Bordenave Designs

February 12, 1996

Attn: Lisa Manwill
Re: K10-D21A

The following letter is written in response to your comments dated 02/02/96. The responses are written in the same order as the comments.

PHASE III GRADING PLAN
ZANIOS FOODS
221 AIRPORT DRIVE NW
ALBUQUERQUE, NM 87121

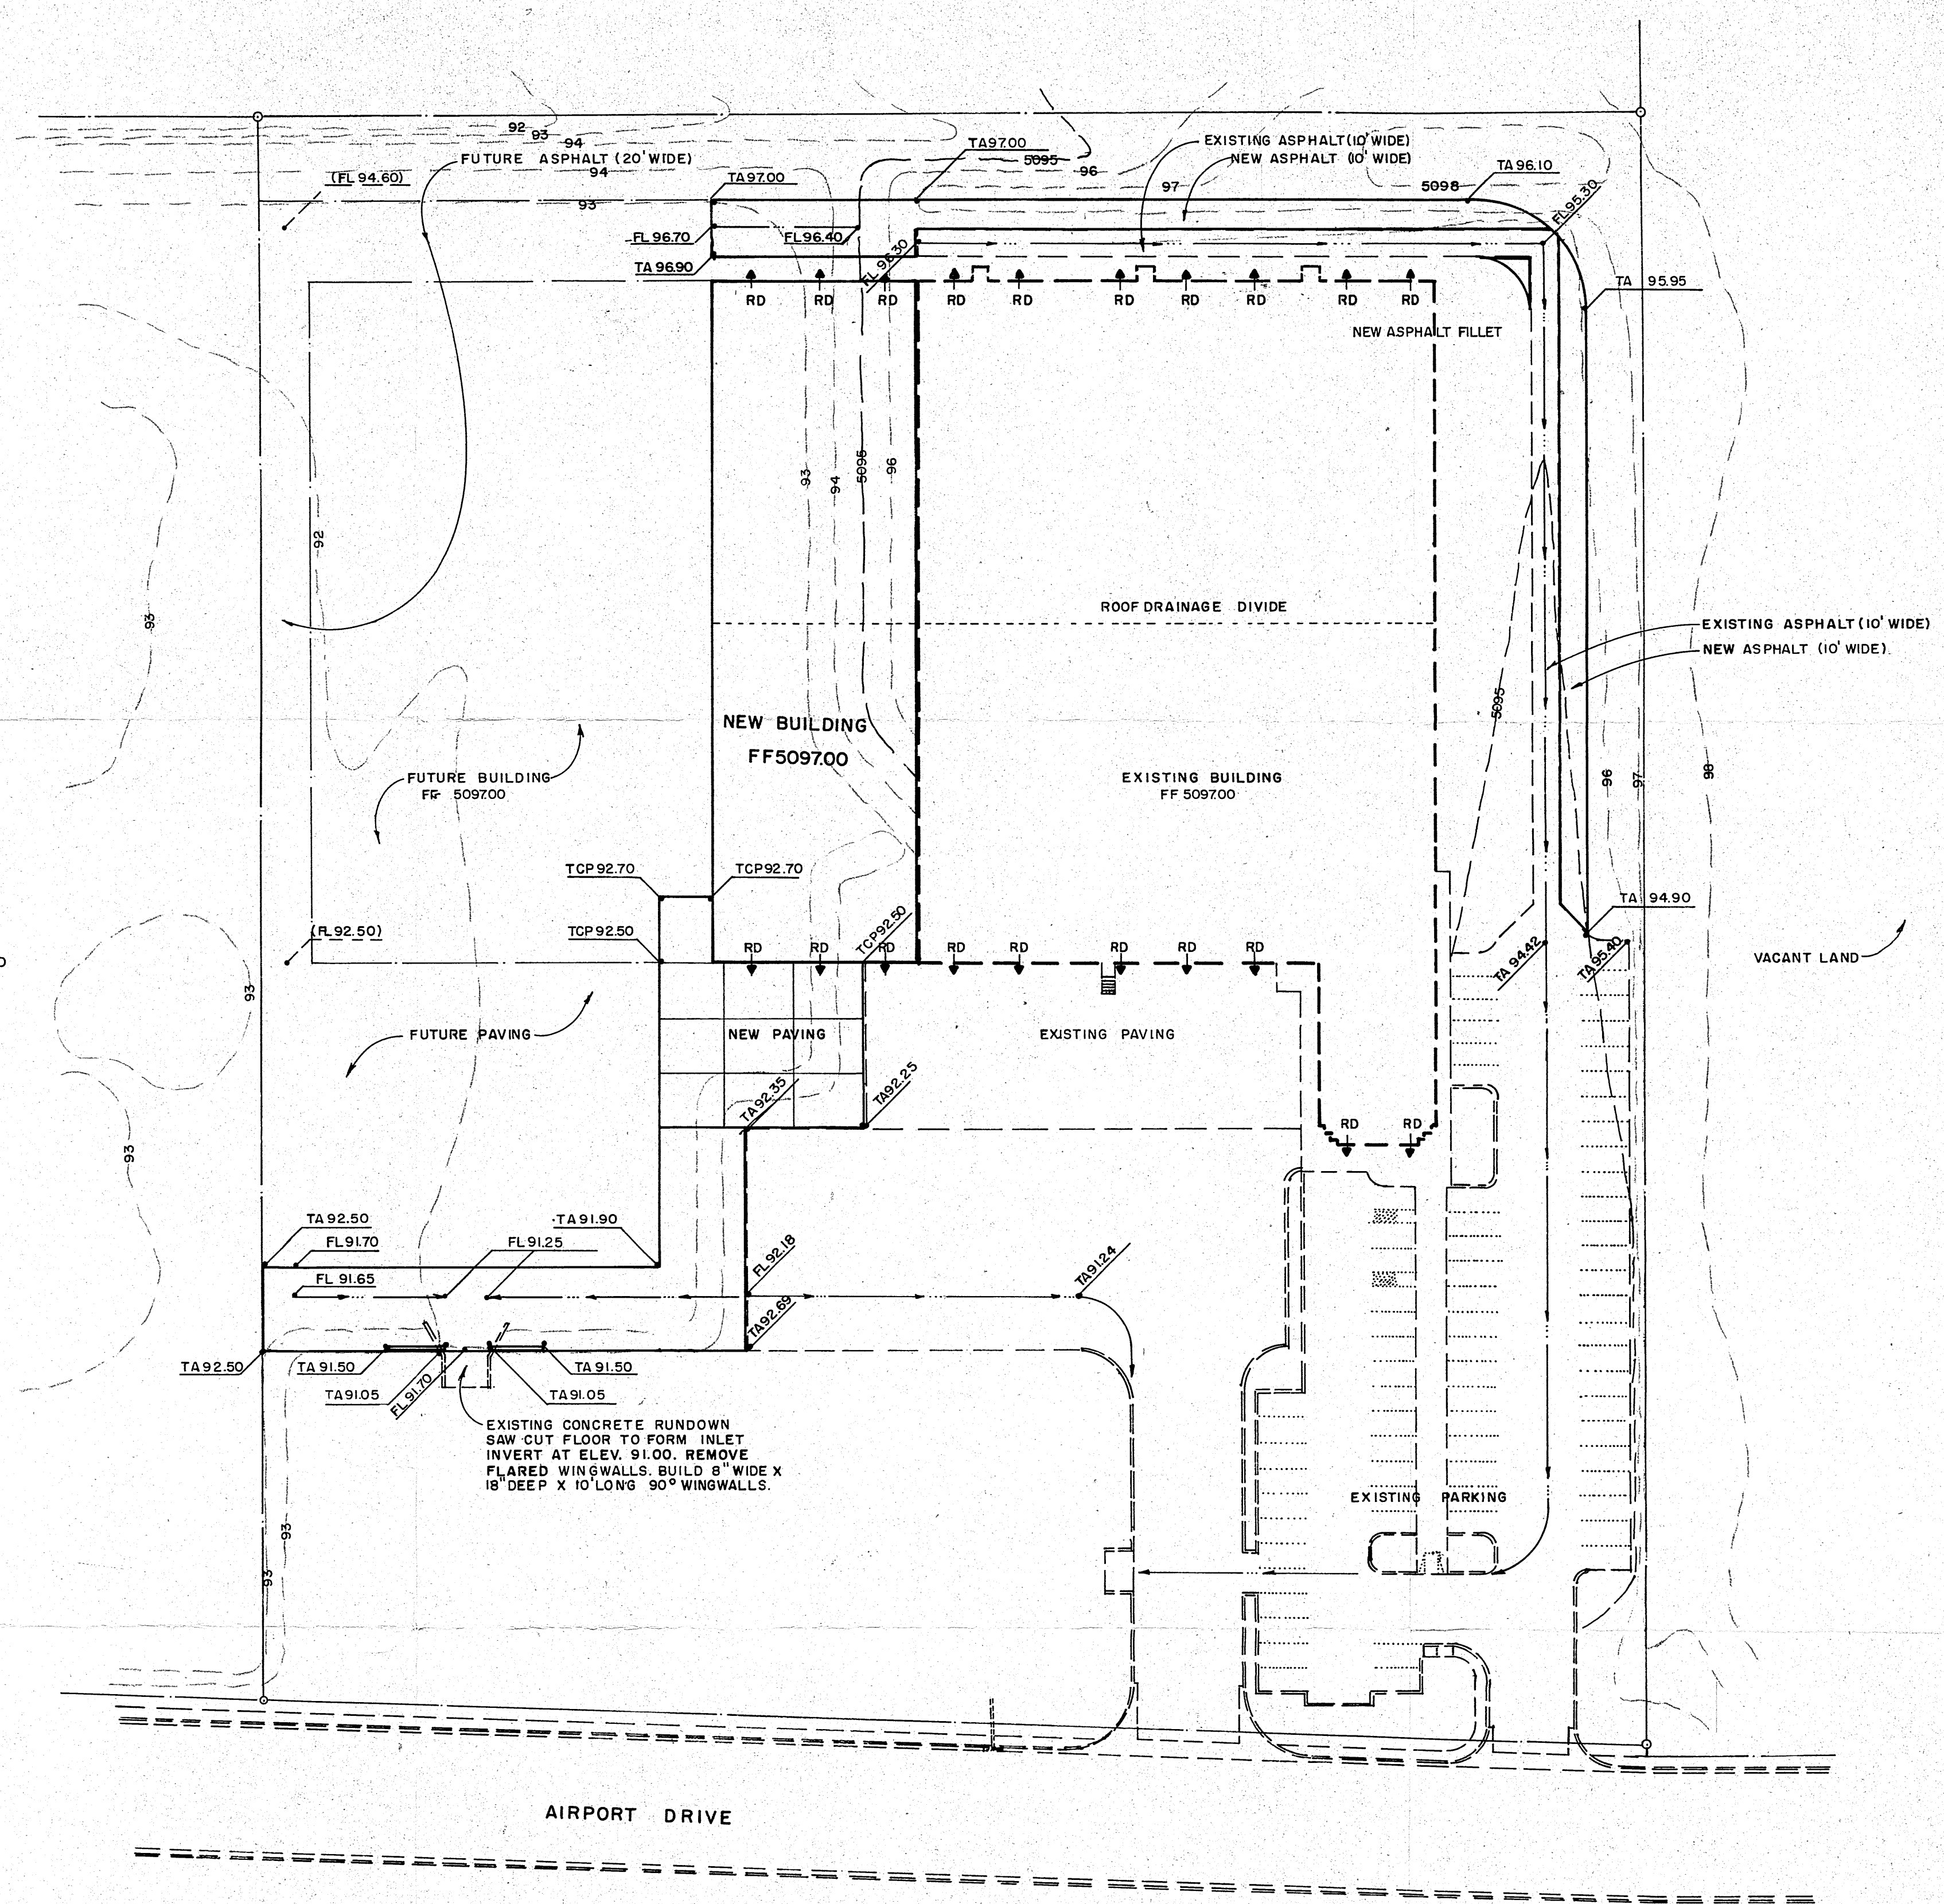
per what
where?
I see calculations for the SD in Airport.
Nothing for this SD
Yes, but it appears that developed calculations were not considered

1. The proposed construction is labeled "new building" and "new paving" as well as the alteration of the existing concrete rundown.
2. The building increases the amount of runoff generated.
3. The drainage calculations are in the file K10-D21.
4. The existing finish floor has been designated as the TBM since it is this item that must match. The designation has been added to the plan.

The site was designed for the ultimate condition and the future construction was shown on the original submittal. This was done to facilitate future reviews and to assure those in the approval process that the facilities were adequate. The detention pond and controlled outlet was constructed in Phase I of the construction.
